31 January 2018

File No: SSD 8373  
Our Ref: R/2017/9/A

**State Significant Development application for the Alexandria Park Community School Redevelopment, Park Road, Alexandria (SSD 8373)**

3 WINTER 3PM
1 : 1000

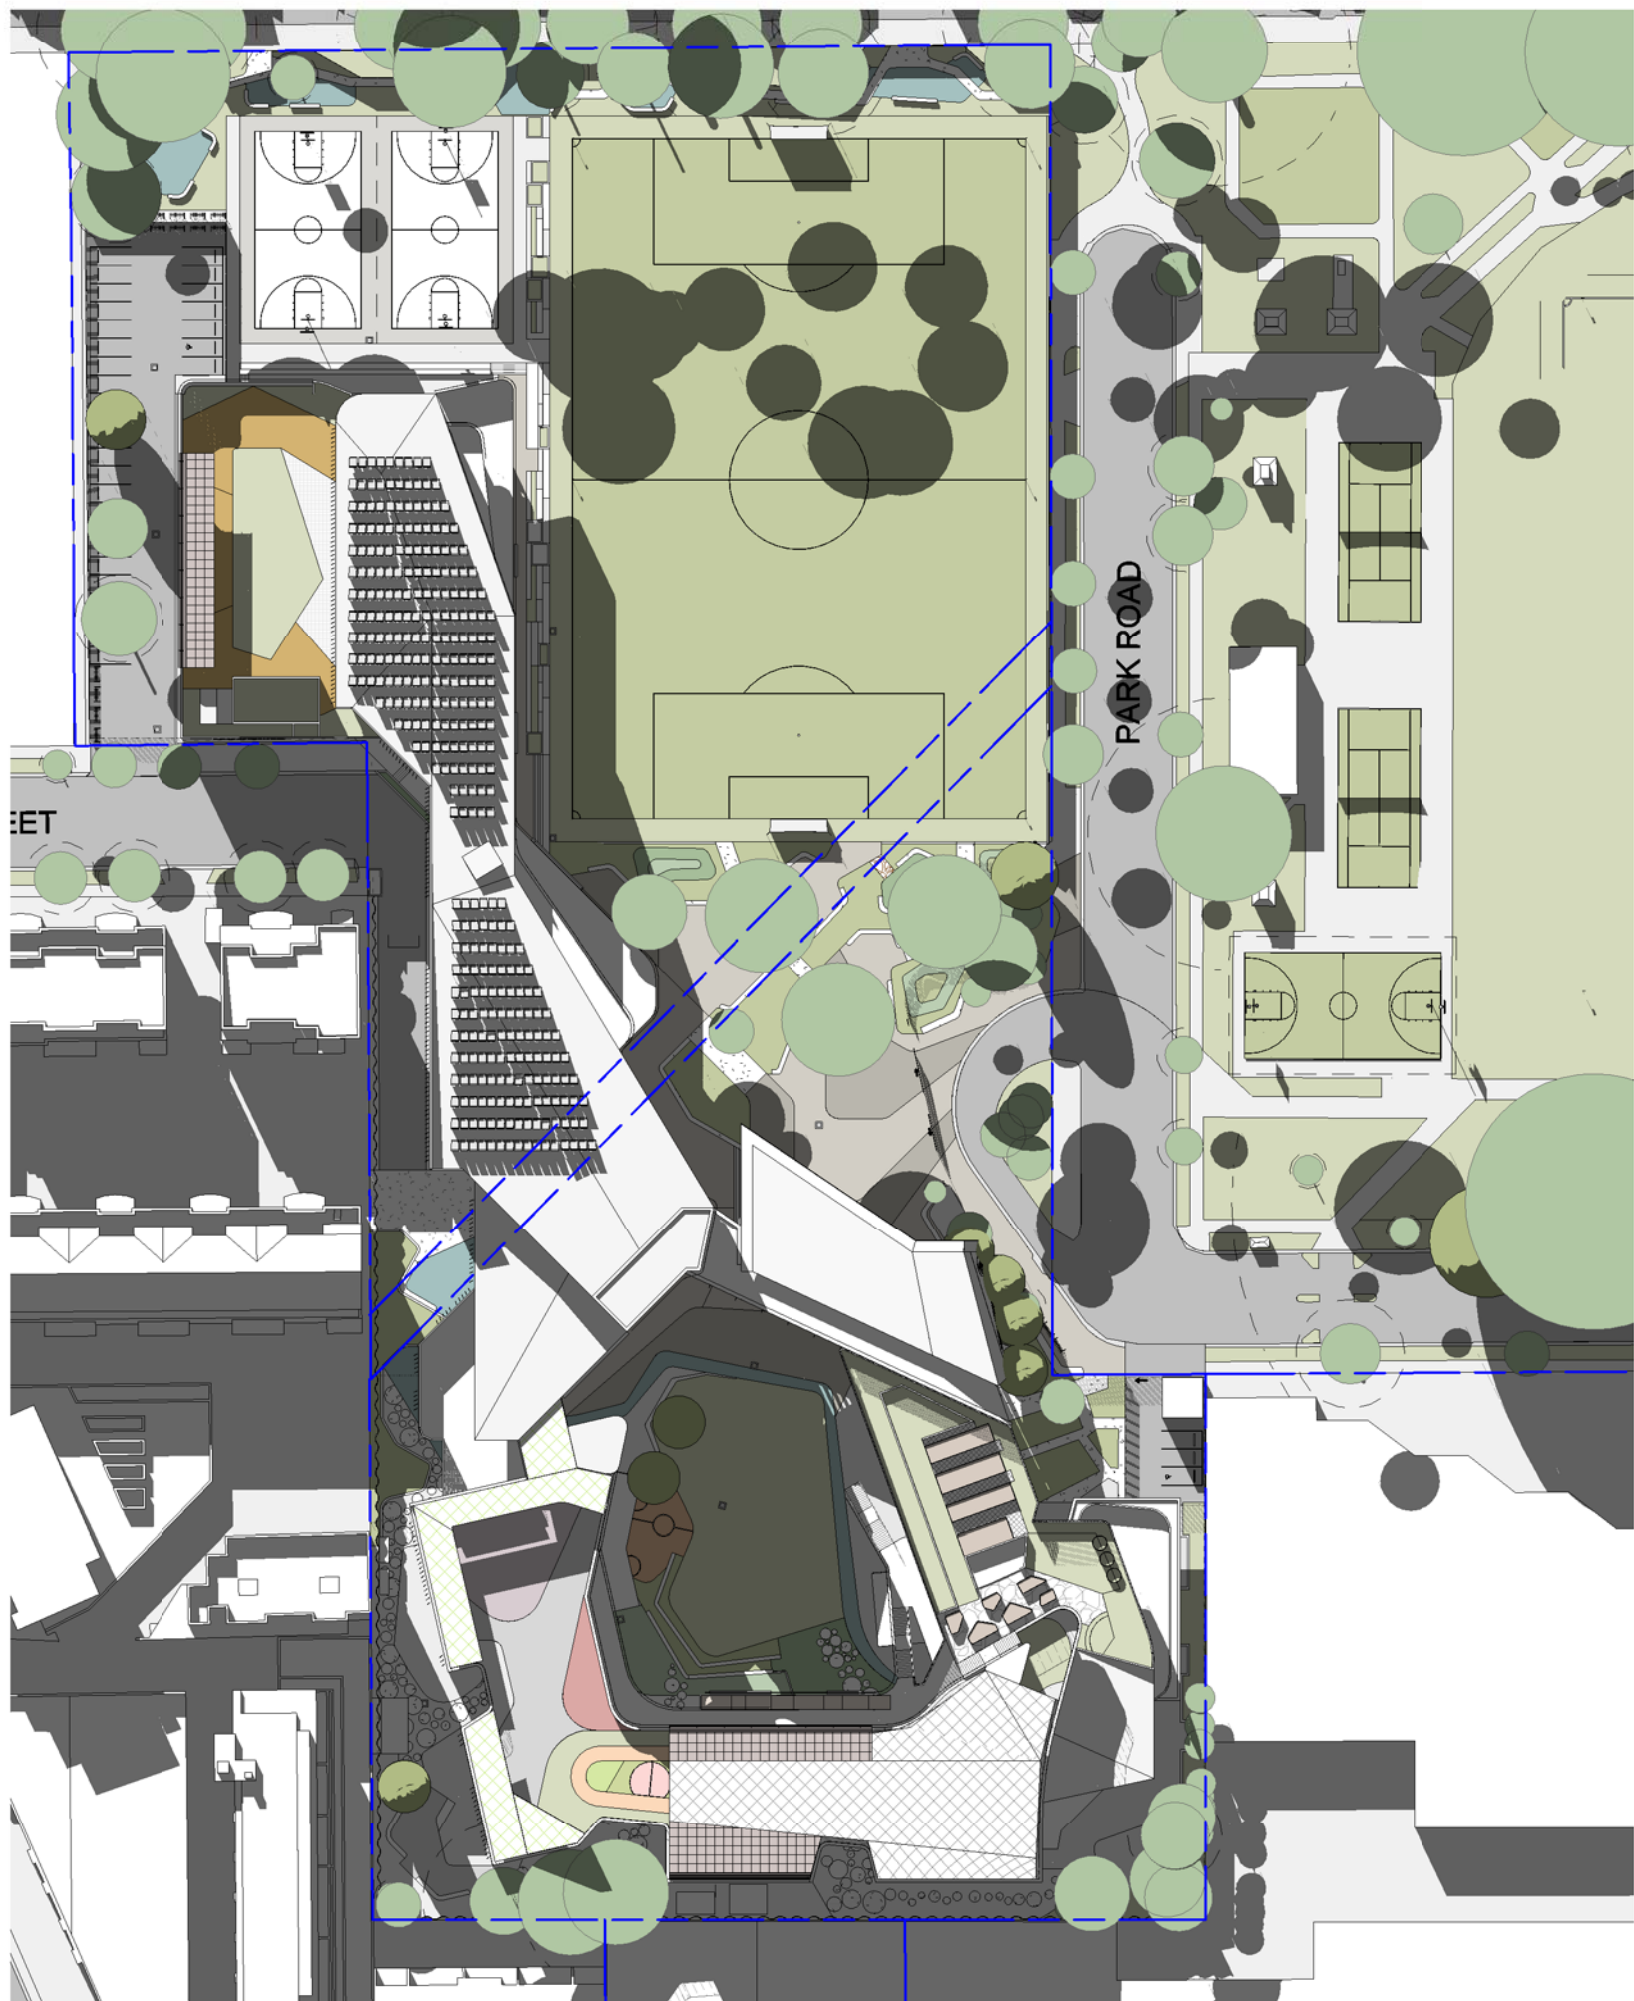
The shadow studies provided at 9am, 12pm and 3pm in midwinter do not provide sufficient detail to fully assess the amenity impacts on adjoining properties. In order to undertake a detailed analysis of the overshadowing impacts, additional material in the form of detailed views from the sun at hourly intervals would need to be provided in relation to the affected properties. Each neighbouring apartment would need to be counted individually and the analysis would need to provide both existing and proposed hours of solar access to living room windows, private and communal open space.
